REQUEST

Current Zoning: MX-2 (mixed use district) with 5-year vested rights
Proposed Zoning: I-2(CD) (general industrial, conditional)

The petition proposes to allow a maximum 2.5 million square foot data center and an electric substation on acreage located at the southeast quadrant of University City Boulevard and Interstate 485 in northeast Charlotte.

STAFF RECOMMENDATION

Project No: 23-CLT-004
Date: January 16, 2023
Designed By: UDP
Checked By: UDP
Sheet No:
RZ-1.0

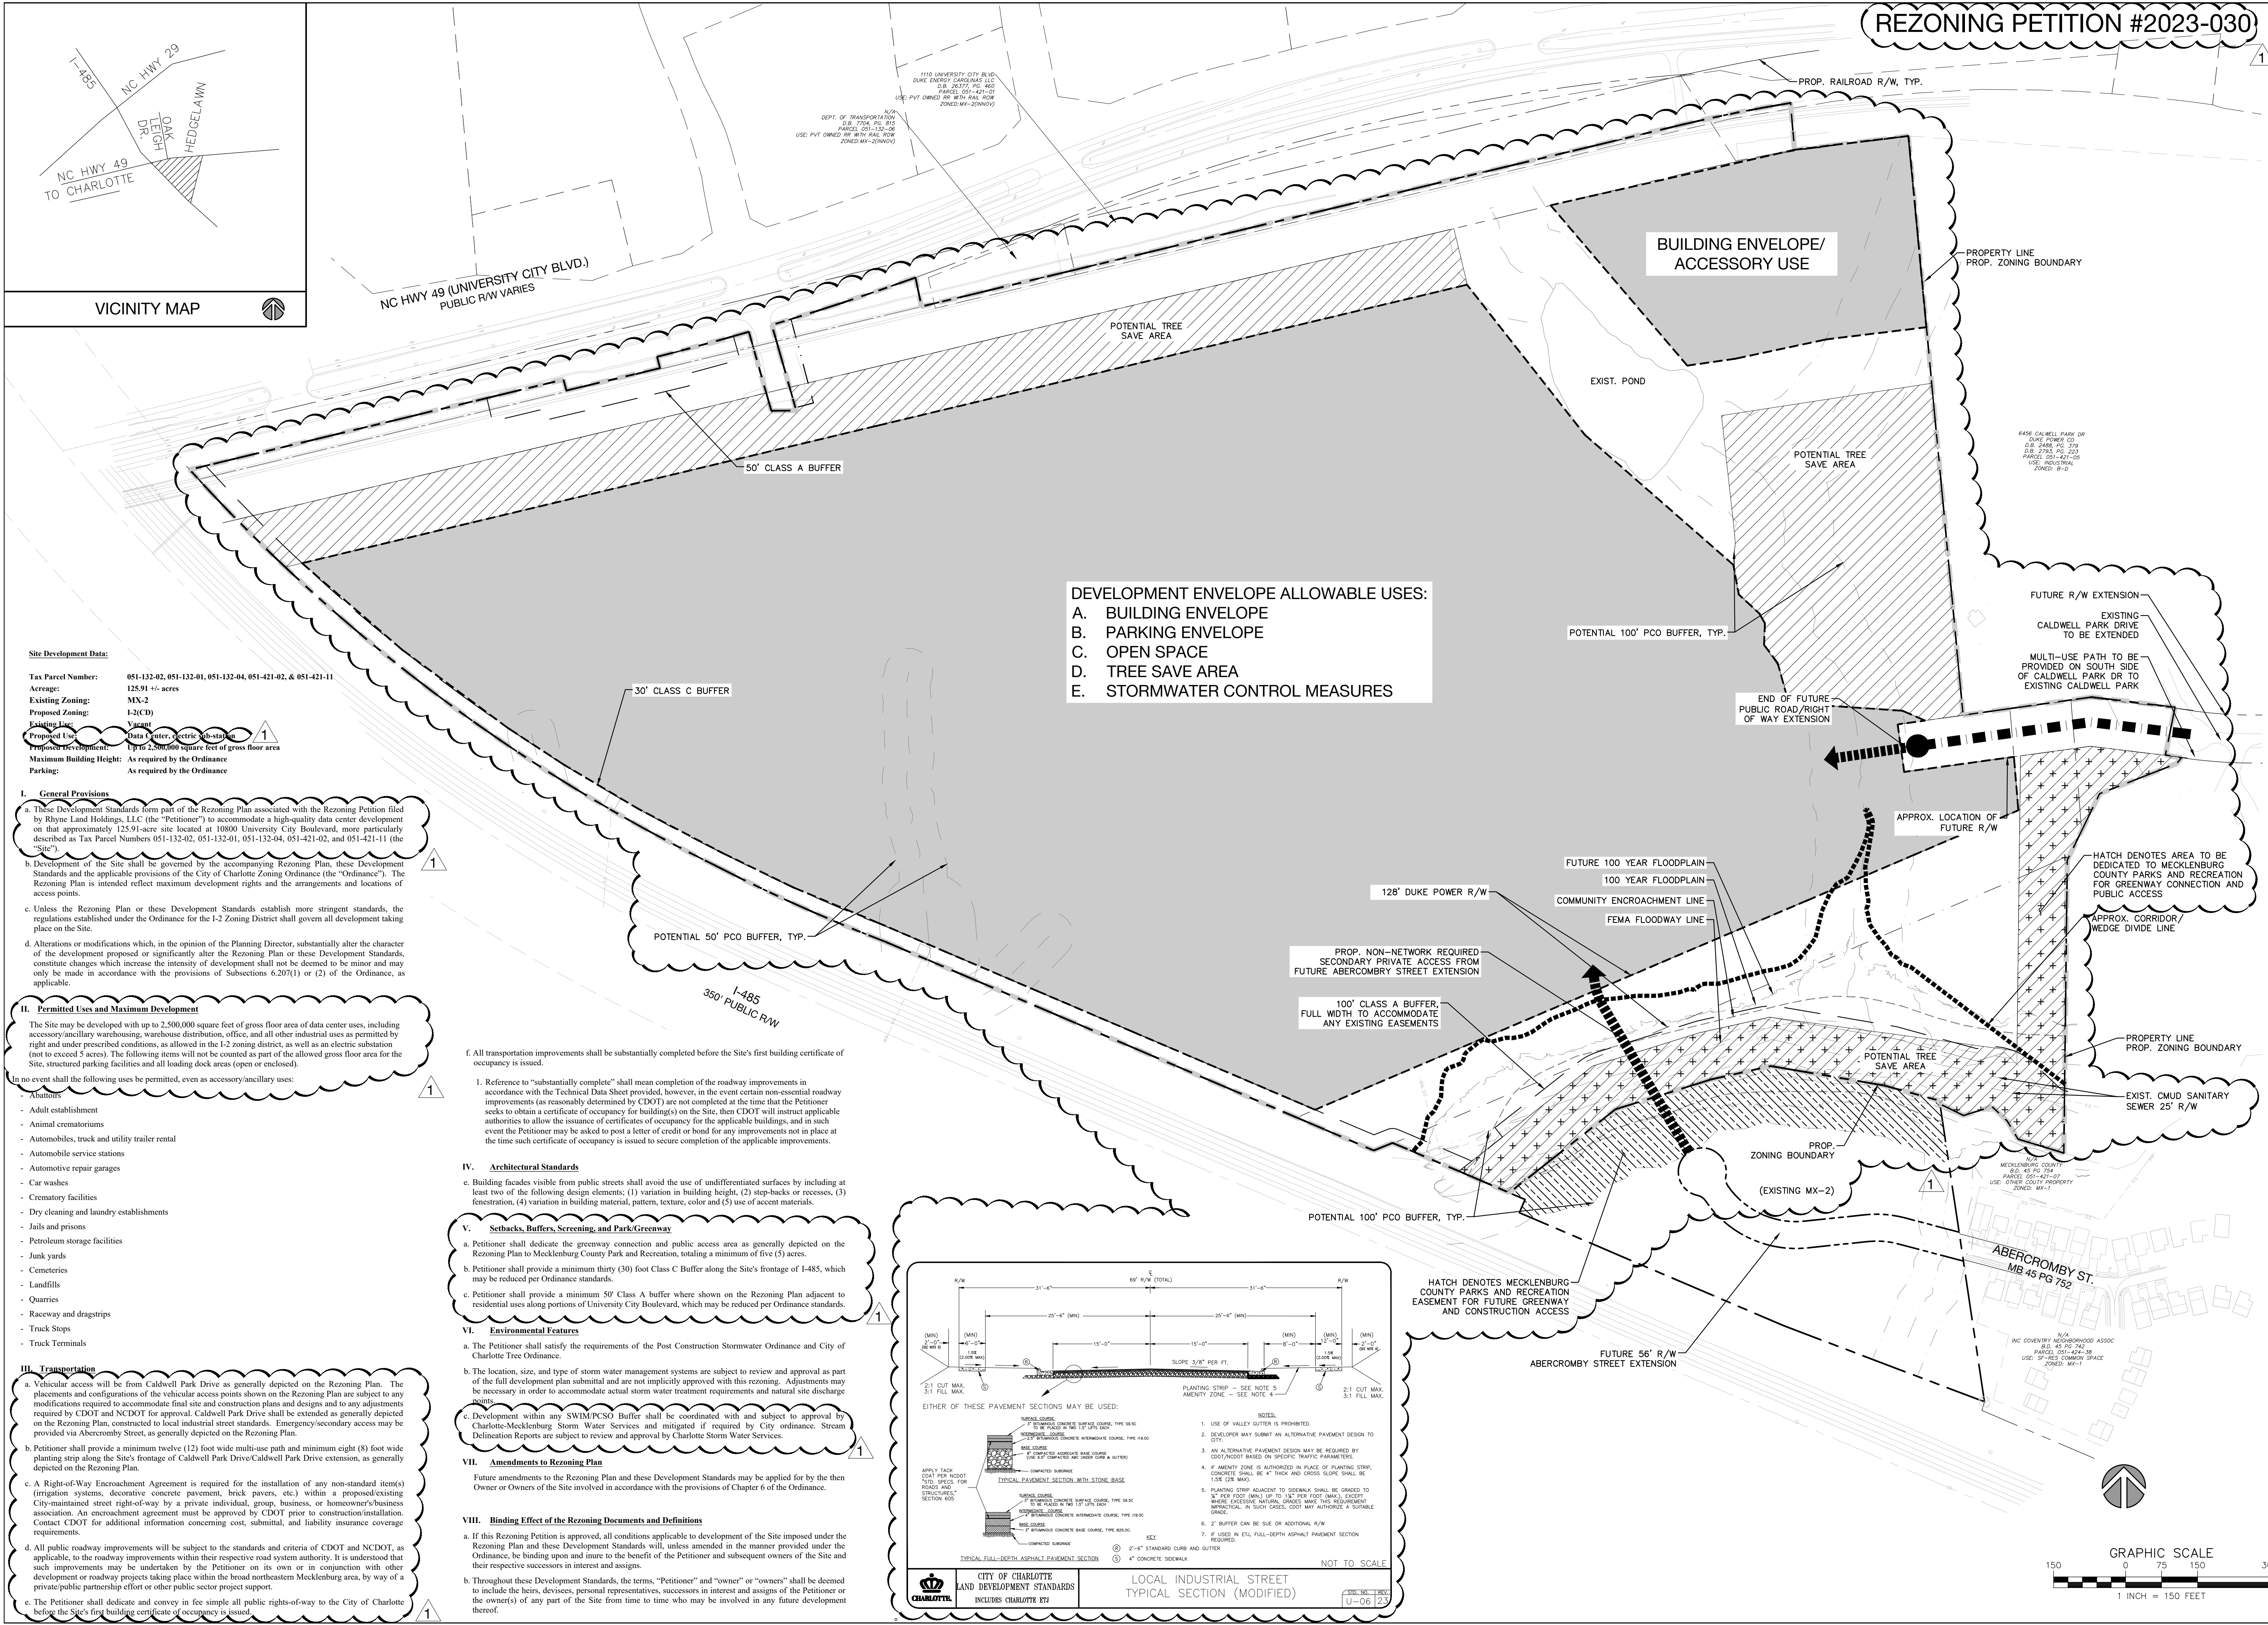
1. Revise site plan and conditional notes to connect Abercromby Street to Caldwell Park Drive. Site access shall be via 1 or 2 standard commercial driveways connecting to this roadway extension. Site plan shall commit to installing signage for all industrial traffic to use Caldwell Park Drive and not Abercromby Street.

2. Add conditional note that petitioner shall construct bicycle facilities by installing a 12' multi-use path with an 8' minimum planting strip along Caldwell Park Drive. The proposed multiuse path should be extended along the southern side of Caldwell Park Drive to the northwest corner of Parcel ID 05114117 owned by Mecklenburg County.

Clarifying Comment 6.21.2023: Label and dimension streetscape elements (12' multi-used path and 8' planting strip) along Caldwell Park Drive/Caldwell Park Drive extension.

3. Provide a more defined location of buildings proposed on the site, particularly those adjacent to the single family residential uses to the south.
4. Provide a berm as part of the 100' buffer to provide additional separation and screening from single family residential uses to the south.
5. Provide clarification on any proposed mitigation for sound impacts associated with the data center use.

RZ-1.0

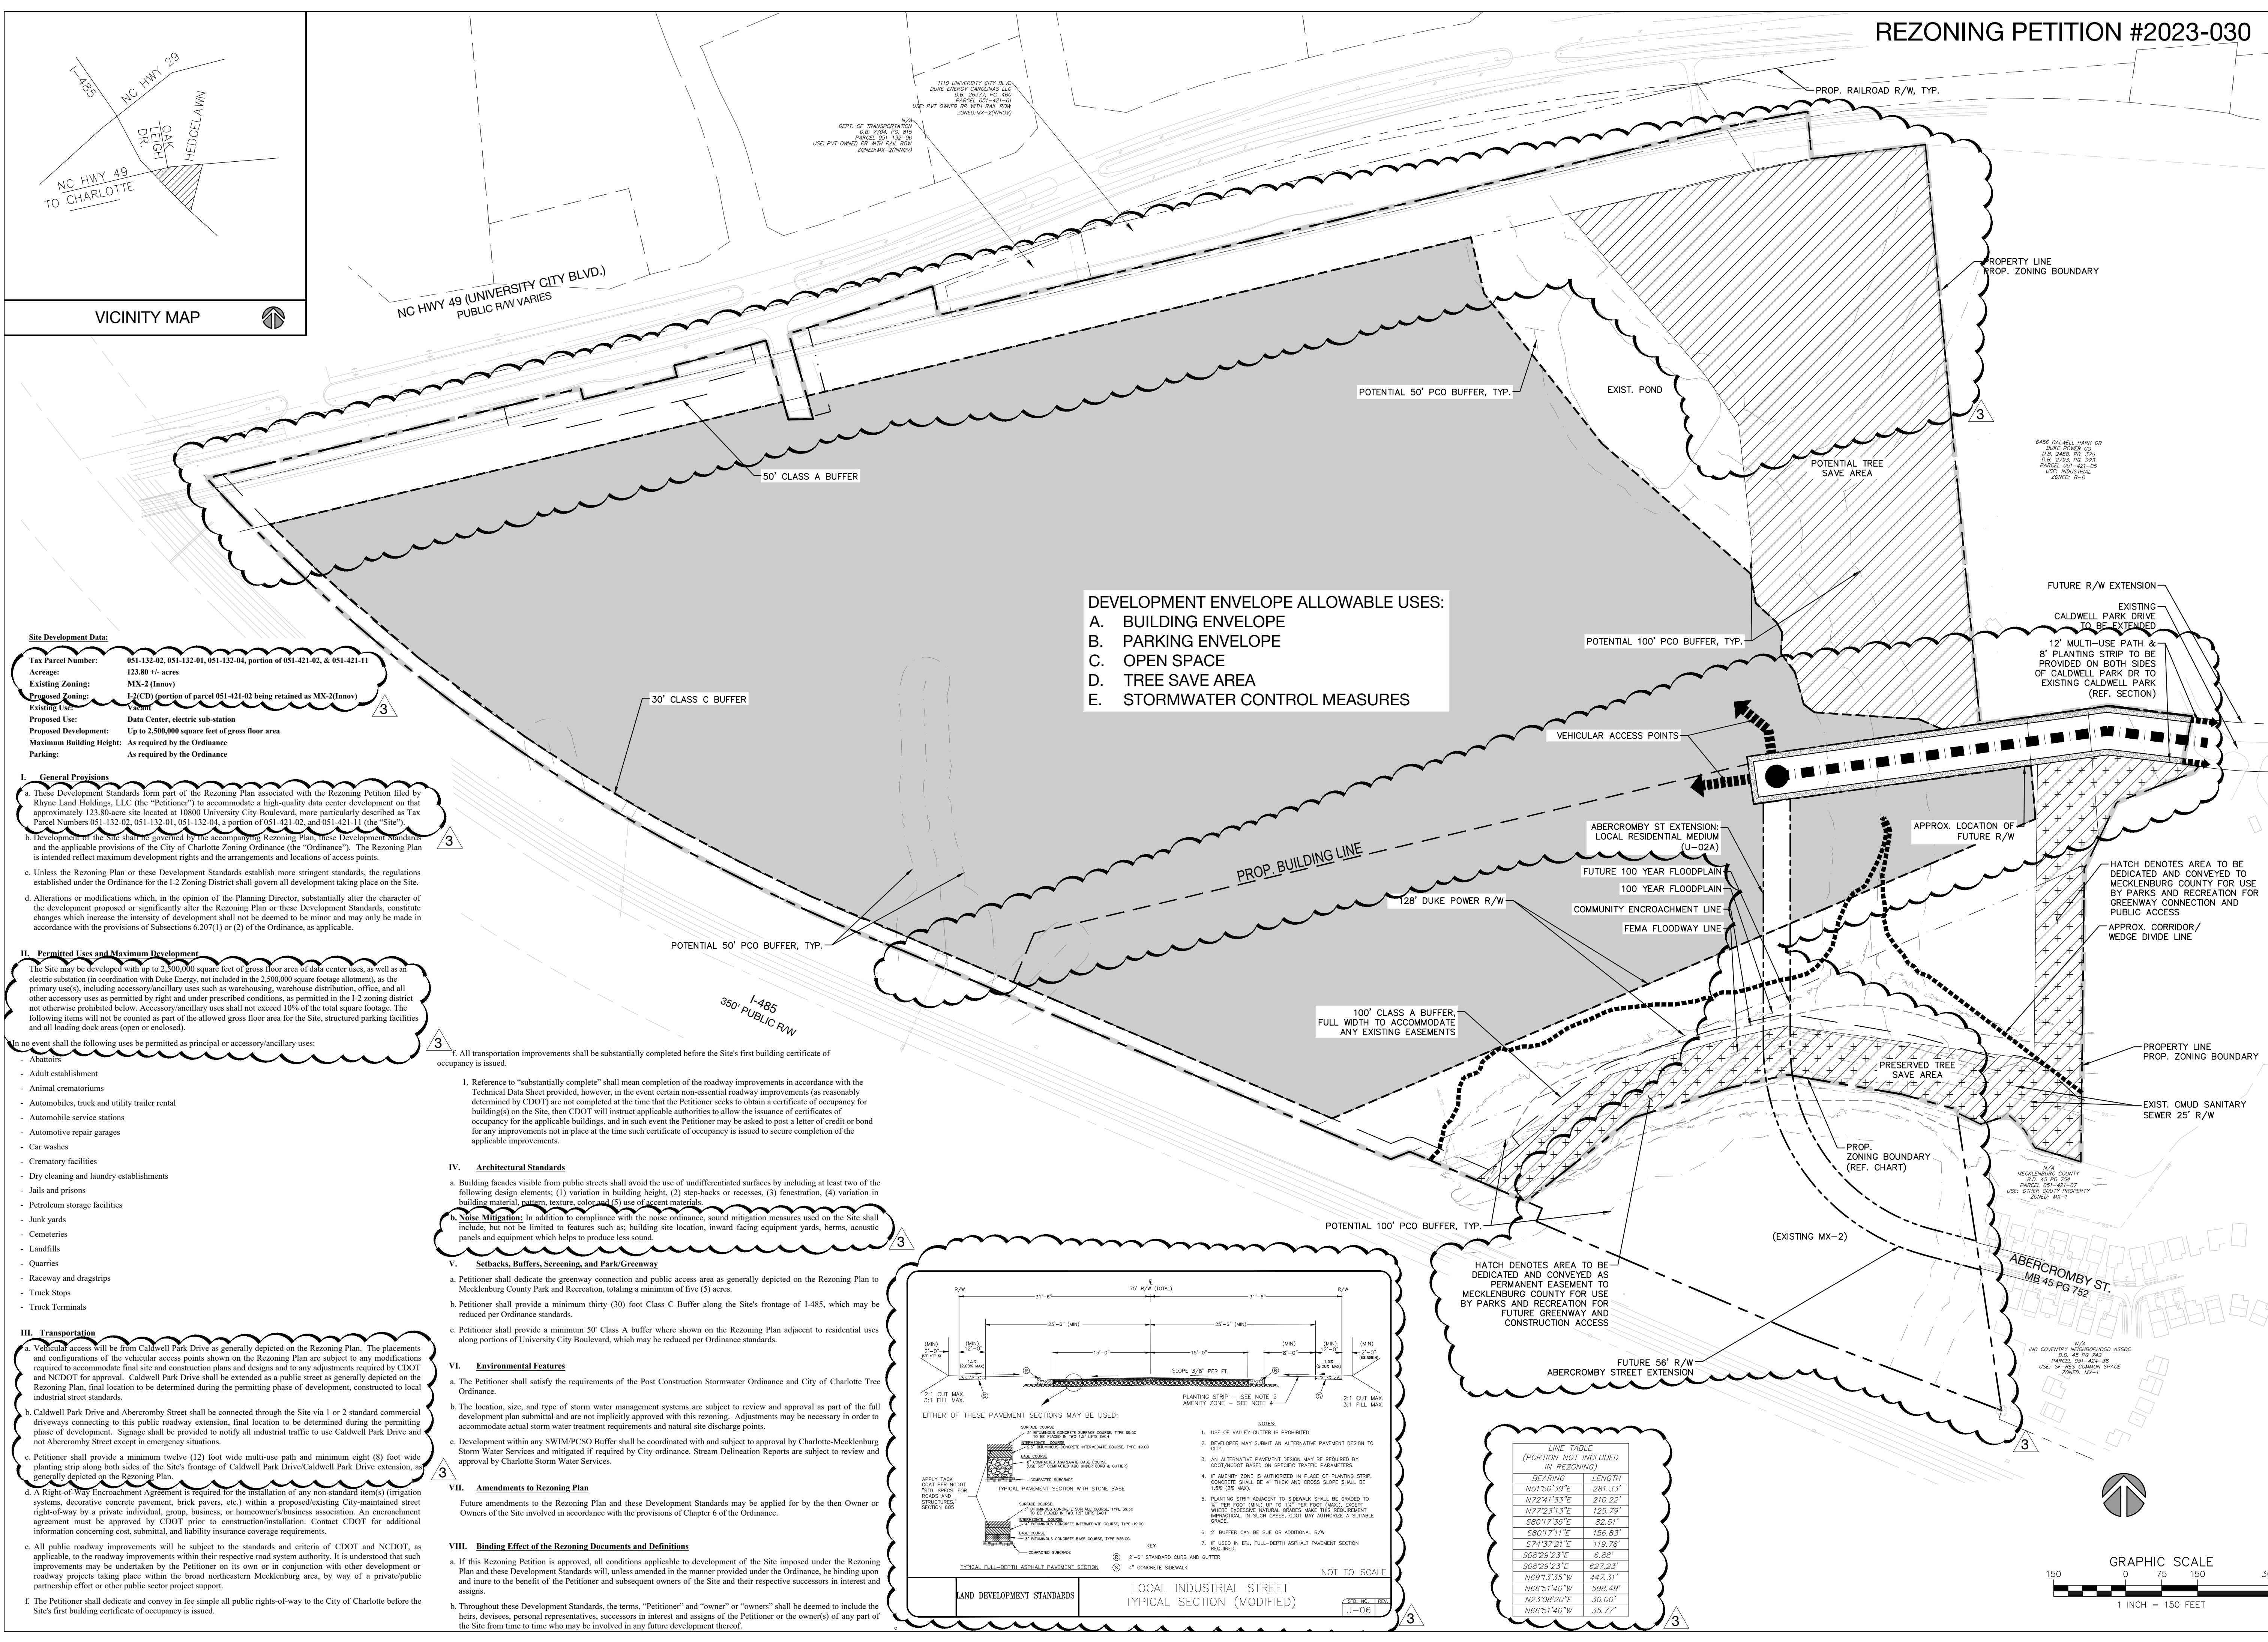
Clarifying Comment 7.28.2023: 12-foot multi-use path shall be placed on both sides of the Caldwell Park Drive extension.
